PLANNING CONSULTATION RESPONSE

Application No	2025/1029
Proposal	Proposed subdivision of existing industrial building into 8 workshop units (Use Class E(g)/B2) with external alterations including partial demolition of the existing building, and refurbishment of existing office block.
Address	Unit 1 Plot 15, Carlton Industrial Estate Plot 4 Albion Road, Carlton, Barnsley, S71 3HW
Date of Consultation Reply	12/03/26
Consultee	Highways Development Control

Consultation Assessment and Justification

Proposed Building and Site Plan
Scale 1:200

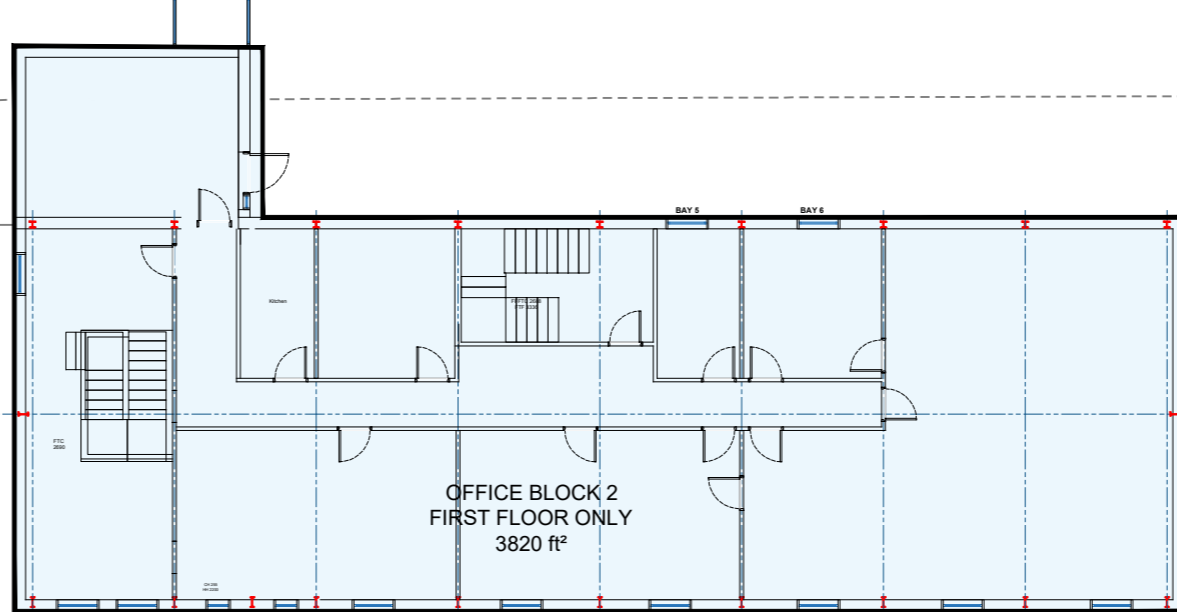
Whilst I have no objection to the principle of the proposed change of use, I note that no details have been provided in respect of parking provision. From Street View imagery, it appears that car parking is available both within the main unit compound and within a separate area to the front of the site, however, it would be beneficial for the number of parking spaces to be confirmed.

I note from the Design and Access Statement that unit sizes will vary between approximately 1,800 sq ft and 6,000 sq ft. I have included Barnsley's parking standards below for B2 use and would ask the applicant to bear in mind that the ratios quoted are in square metres (m²).

- 1 space per 50 m² up to 500 m² (all development less than 500 m²)
- 1 space per 60 m² (all development between 500 m² and 2,500 m²)

If the applicant could confirm the number of parking spaces to be provided, I will happily reassess this matter as a priority.
